Our ref: WA/2022/129578/02-L01
Your ref: 21/04275/OUT
Date: 09 January 2023

Outline - with all matters reserved except for access - mixed use development of up to 3,100 dwellings (including extra care); residential and care accommodation(C2); mixed use local centre (comprising commercial, business and service uses, residential uses, C2 uses, local community uses (F2(A) and F2(B)), hot food takeaways, public house, wine bar); employment area (B2, B8, e(g)); learning and non-residential institutions (class F1) including primary school (plus land to allow extension of existing gagle brook primary school); green infrastructure including formal (including playing fields) and informal open space, allotments, landscape, biodiversity and amenity space; burial ground; play space (including NEAPS/LEAPS/MUGA); changing facilities; ground mounted photovoltaic arrays; sustainable drainage systems; movement network comprising new highway, cycle and pedestrian routes and access from highway network; car parking; infrastructure (including utilities); engineering works (including ground modelling); demolition

Part OS Parcel 8149 Adj Lords Lane And SE Of Hawkwell Farm, Lords Lane, Bicester

We hav

Figure 6-2: EA Flood Zone Plan showing 1 in 100 & 1 in 1,000 year floodplains

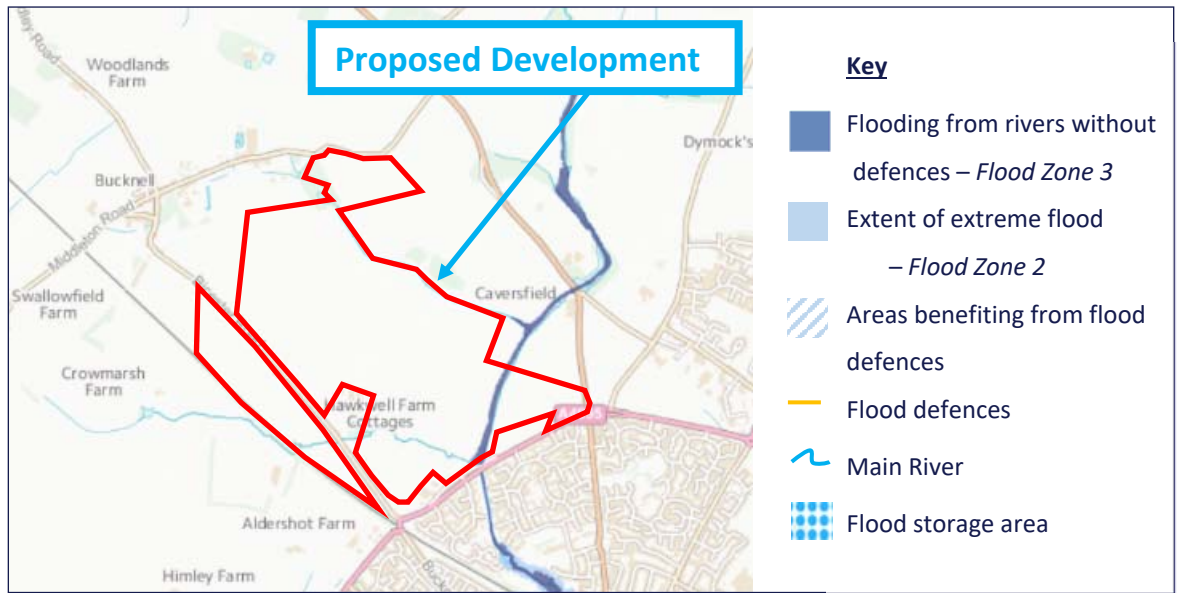
The technical note states that the development will be designed in relation to the risk of flooding as shown on the Environment Agency flood map for planning and by setting development parcels 25 metres back from the watercourse.

The flood zones in this location are derived from national generalised modelling which does not take account of any locally relevant information or any increased risk of flooding due to climate change. For this reason, it is not suitable for use within a site specific Flood Risk Assessment (FRA).

The applicant will therefore need to undertake a more suitable level of assessment to determine the expected extent of flood risk at this site and the FRA revised accordingly following the guidance on how to prepare a FRA which can be found at <https://www.gov.uk/guidance/flood-risk-assessment-for-planning-applications>

For an outline planning application with design, layout and scale reserved for later approval, as a minimum we would expect the FRA to identify the extent of flooding and the expected depth of flooding for a range of critical flood events both now and in the future due to climate change. The design flood extent and level should be identified and confirmation that the sequential approach to placing development in the lowest area of flood risk is feasible and design principals established which can be taken forward to reserved matters.
